**Consultation Response from KC,  
Highways Development Management****2025/91903 Land adjacent, 837, Manchester Road, Linthwaite, Huddersfield, HD7 5NF****Erection of dwelling (within a Conservation Area)****Date Responded: 20-10-2025.****Responding Officer: Mark Berry.****Responding Ref: 20-10-2025.**

This application seeks approval to the erection of a dwelling at land adjacent, 837, Manchester Road, Linthwaite, Huddersfield.

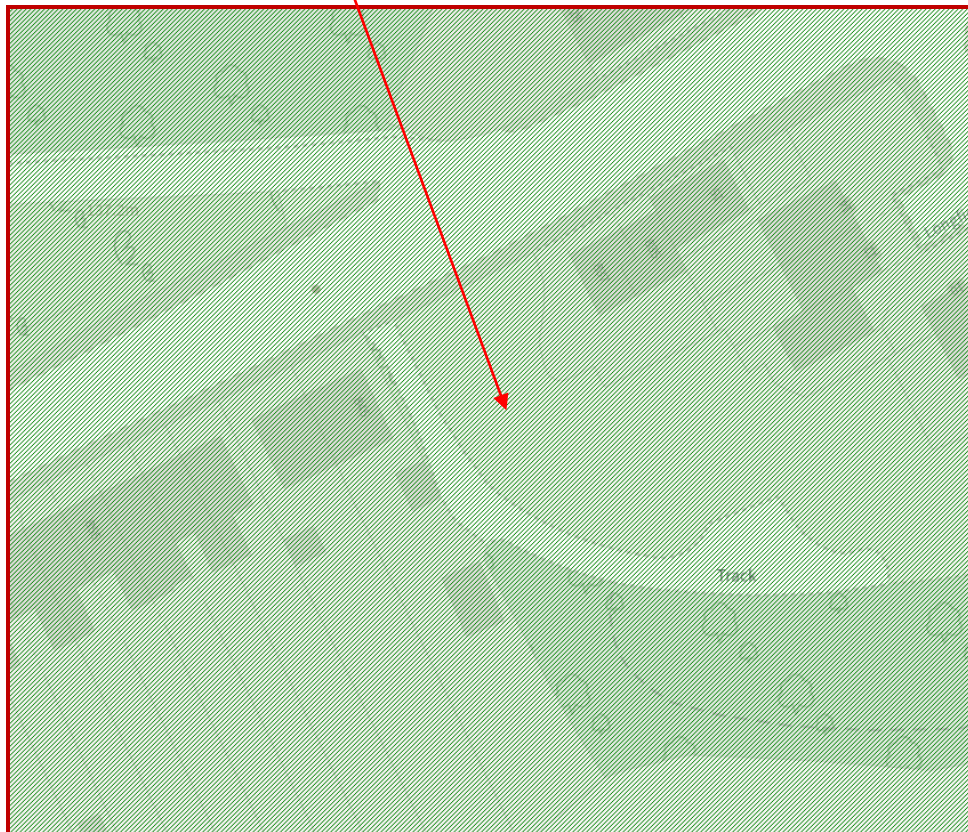
Bin collection points should be shown to be provided to enable bins to be presented on collection day without either obstructing the footway along Manchester Road or the existing access track
